Application number: 2026/90291	
What is the application for?:	Alterations to existing outbuilding to create dwelling forming annex accommodati
Address of the site or building:	116, Gawthorpe Lane, Lepton, Huddersfield, HD5 0NZ
Postcode:	HD5 8EA

Regarding planning application: 2026/90291 (proposed conversion of storage barn to dwelling at 116 HD5 0NZ)

**4: Existing South Elevation**  
1 : 50

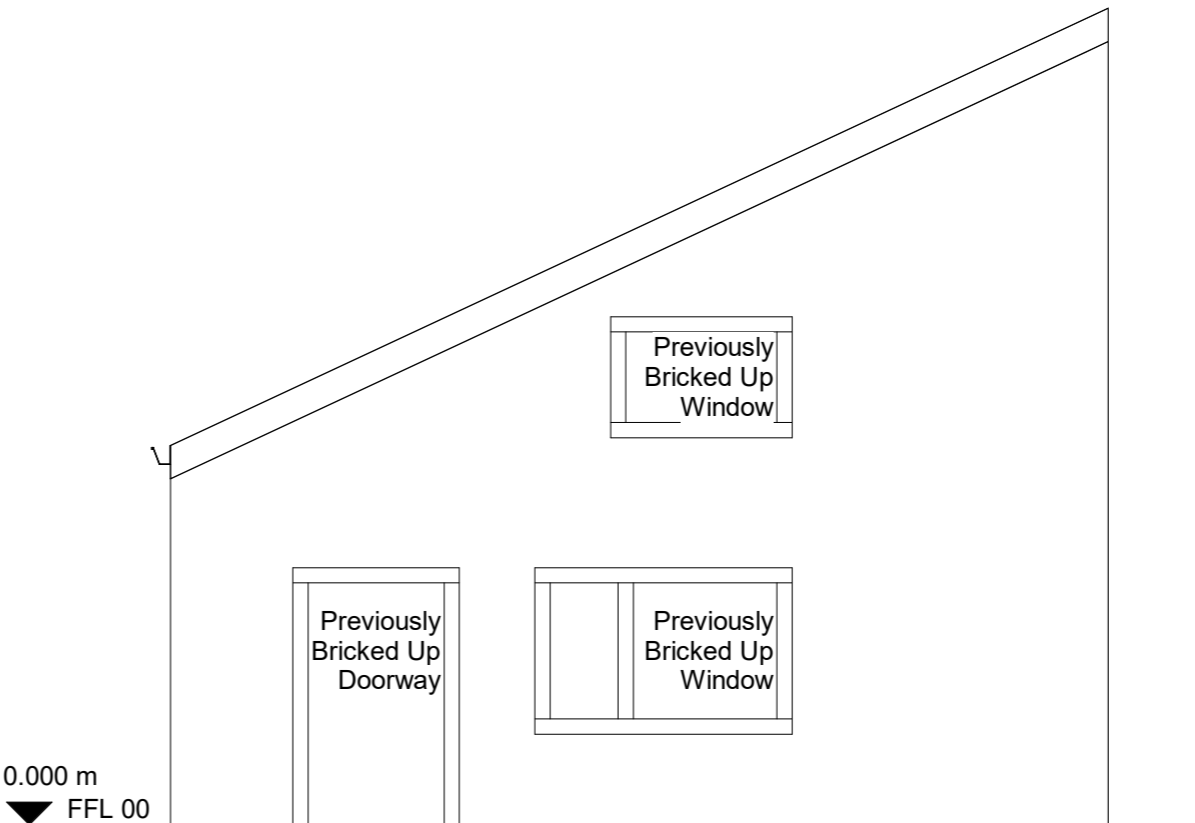
Vehicles are not permitted to stop or park on the drive, other than for No. 112. No. 114 has drive-through access. The area at the end of the drive (in front of the barn south elevation wall, as shown on the Existing Key Elevation Plan) is used for manoeuvring in and out of parking at No. 112 and for No.114 to wait while their electric gate opens. This area needs to be remain accessible.

I'd therefore be grateful if any permission could include conditions enduring that neither the building works nor the finished development cause any narrowing, protrusions, or obstructions that could hinder normal vehicle movements on the drive. I'd ask that no pipes/fixtures are fitted onto the external south elevation wall.

The plans don't show any external repair works to the south elevation wall. Should work be required it would need to be carried out from our side at No. 112. I would be grateful if access could always be agreed in advance. It won't be possible to put up scaffolding or park construction vehicles or plant on the drive itself.

Proposed Site Plan
1 : 500

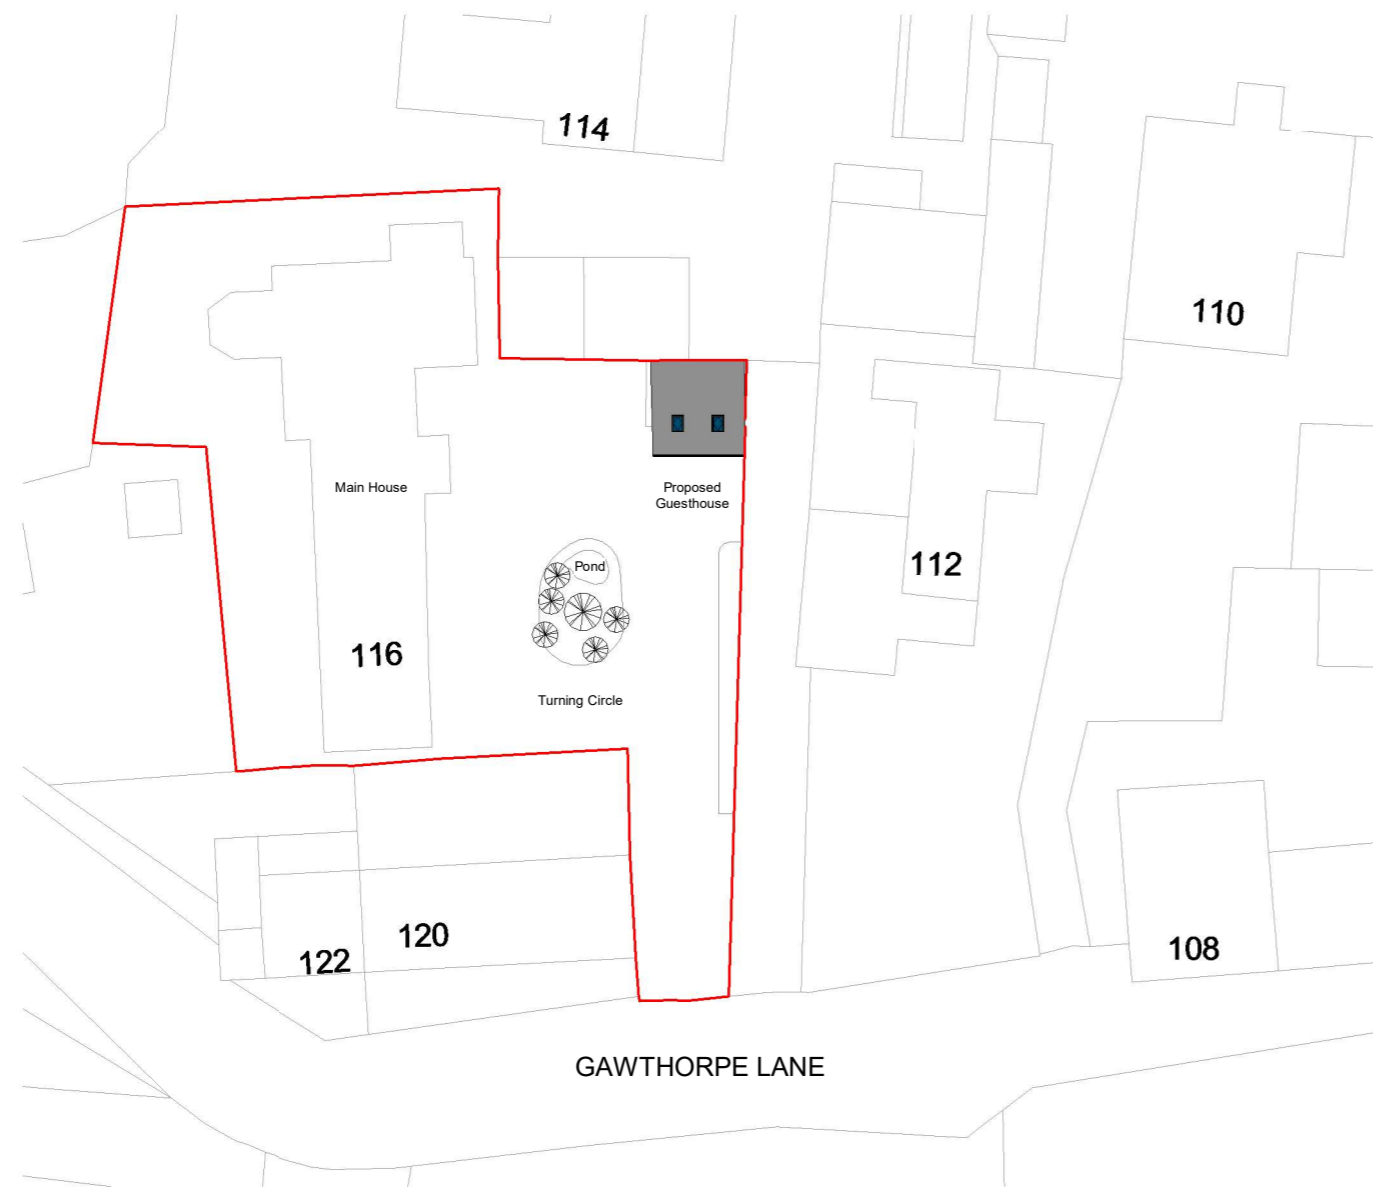
To clarify, the area marked "PUBLIC FOOTPATH" on the proposed site plan is in fact a private drive belonging to No. 112. It is not a public highway or adopted footpath. There is a pedestrian right of way through to the woods behind No. 114.
